GUJARAT NRE 1 Application for s75W Modification to MP 10_0046 Preliminary Works Project - Longwalls 4 & %, Maingates 6-8

Application MP 10_0046 - MOD1

Comments on this Application by Dr Ann Young

August 2012

Figure 8 - Swamps with New LW5 Layout

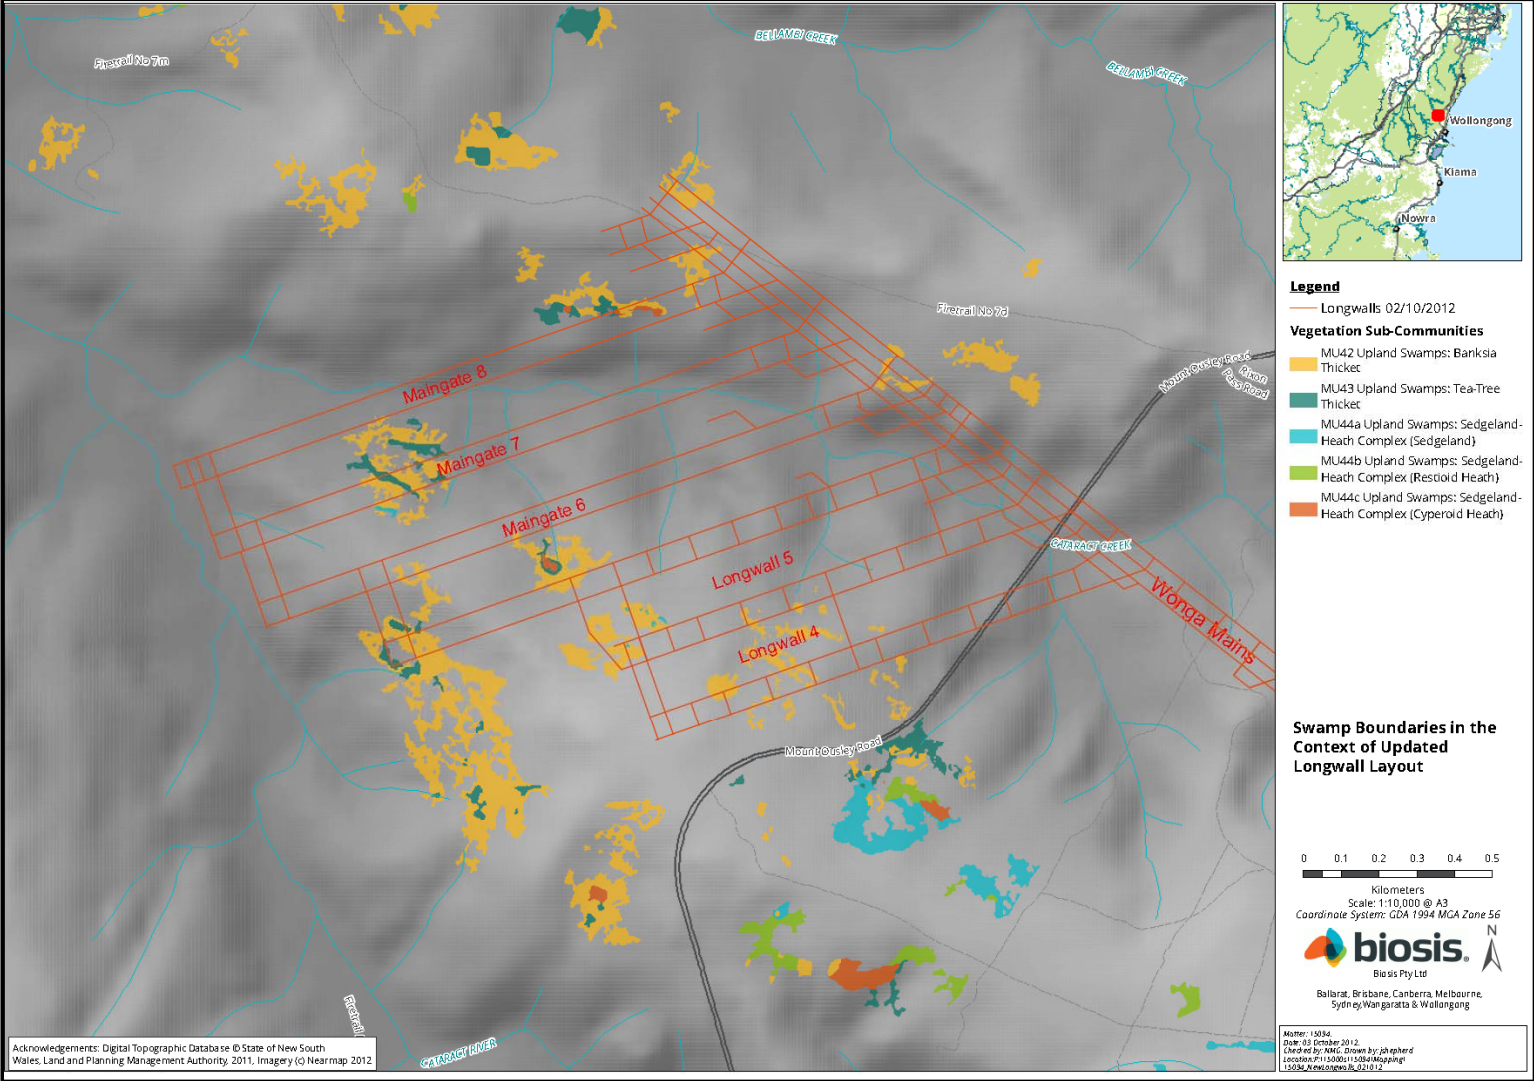
Only one swamp CCHS3 (3.5 ha) will be undermined directly and the EA argues that LW5 has been reduced to minimise impact on this swamp. Another larger swamp CRHS1 (11.4 ha) lies immediately south of the longwalls and CCHS4 (1.8 ha) lies on the western margin. All these are recorded as having 'special significance status' under DECCW 2011 draft guidelines on upland swamps.
